**EL PASO COUNTY PLANNING AND
 COMMUNITY DEVELOPMENT
 DEPARTMENT**

GRADING AND EROSION CONTROL PLAN CHECKLIST

SF2132

STERLING RANCH FILING NO. 2  
**GRADING AND EROSION CONTROL PLAN**  
 SHEET 3 OF 7  
 JOB NO. 25188.00

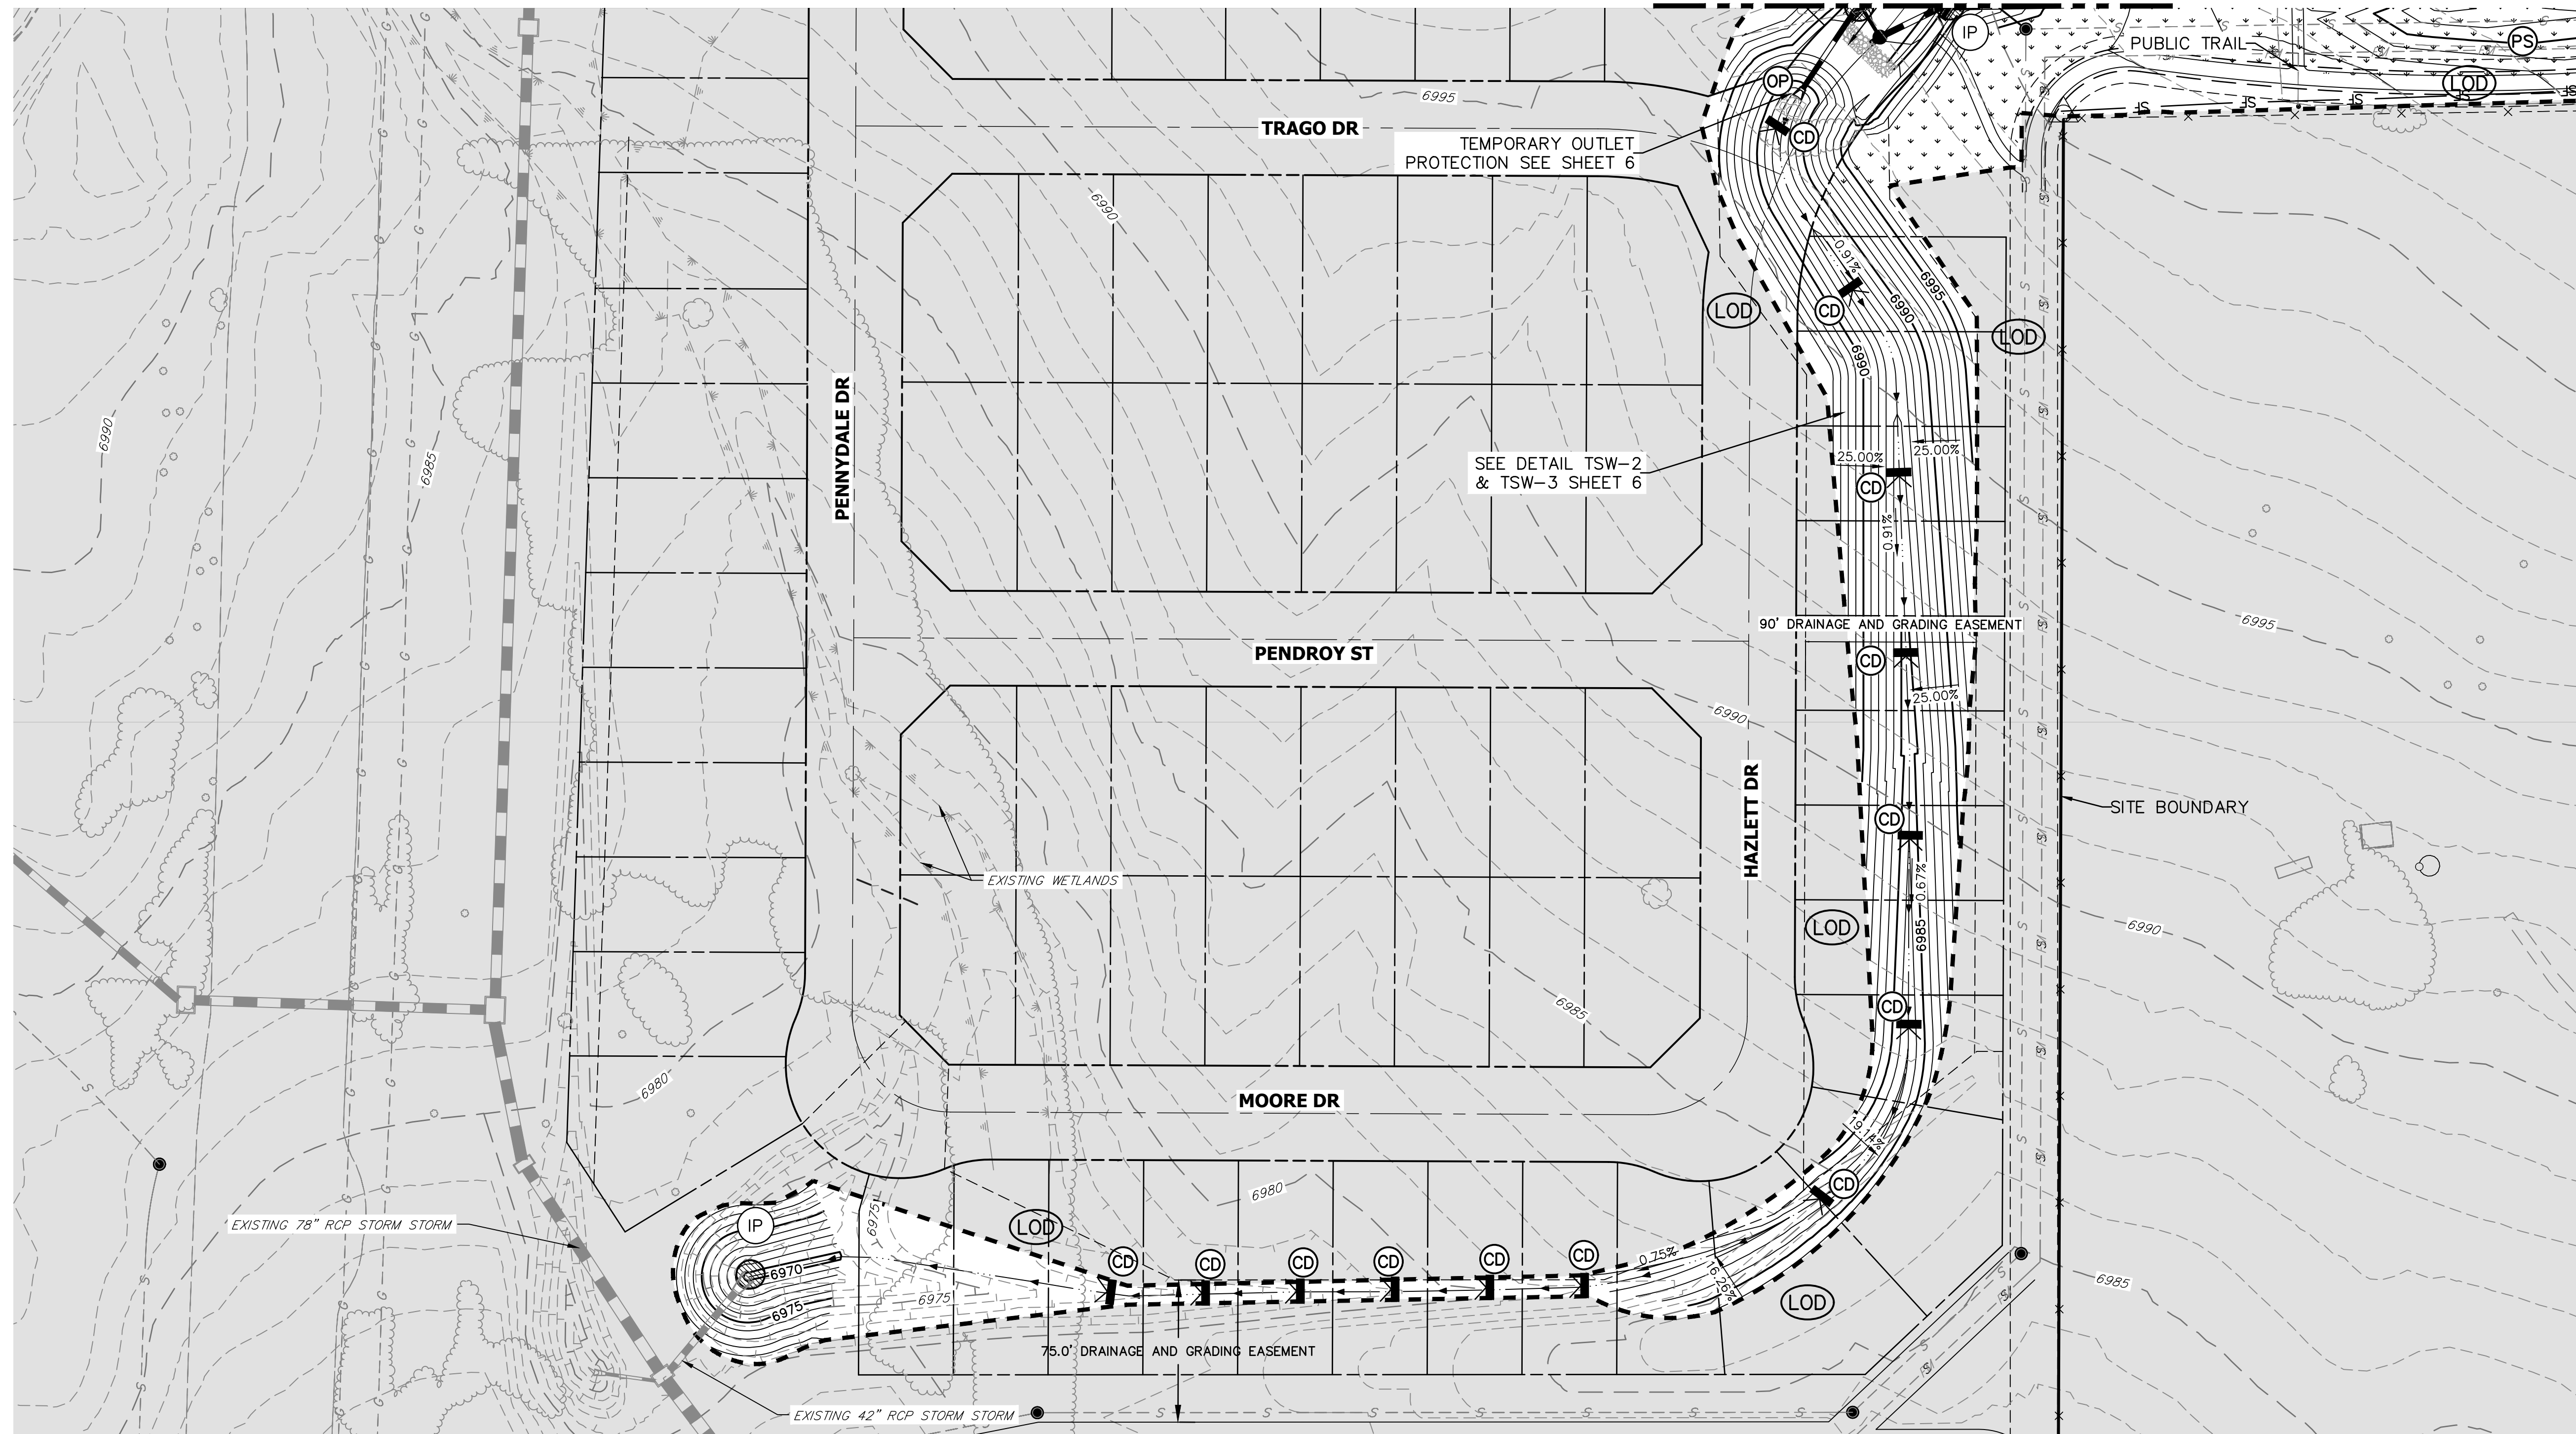
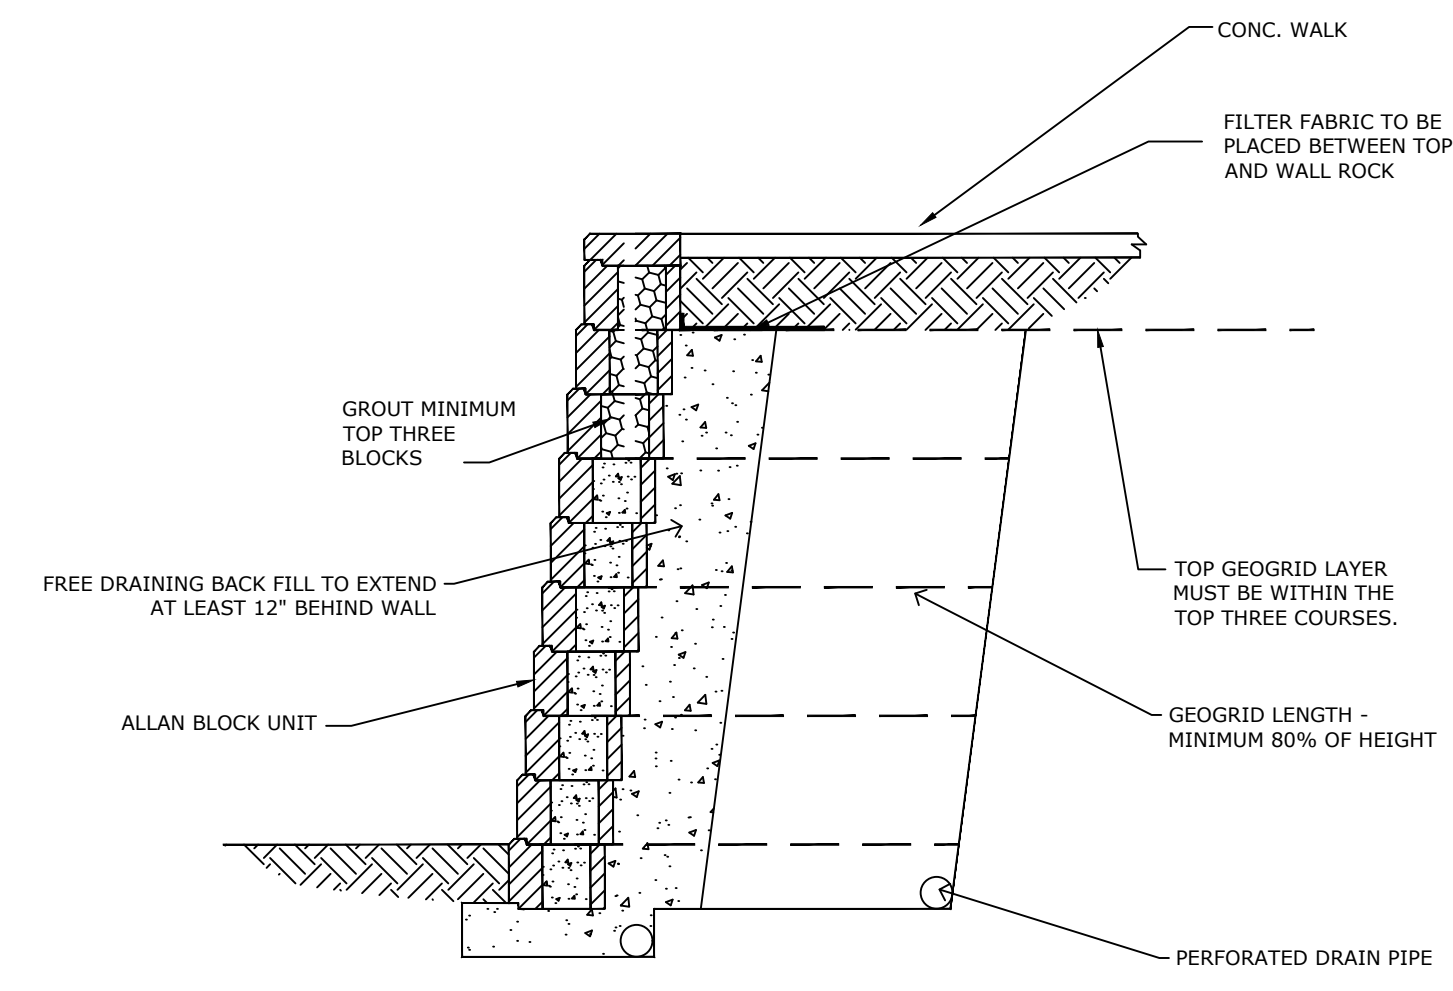
v	All proposed temporary construction control measures, structural and non-structural. Temporary construction control measures shall be identified by phase of implementation to include "initial," "interim," and "final" or shown on separate phased maps identifying each phase. Labels shown in Legend. Revise to "Y".	N/A	Y
w	Vehicle tracking provided at all construction entrances/exits. Construction fencing, barricades, and/or signage provided at access points not to be used for construction.	Y	Y
x	Temporary sediment ponds provided for disturbed drainage areas greater than 1 acre.	Y	Y
y	Dewatering operations to include locations of diversion, pump and discharge(s) as anticipated at time of design.	N/A	N/A
z	All proposed temporary construction control measure details. Custom or other jurisdiction's details used must meet or exceed EPC standards.	Y	Y
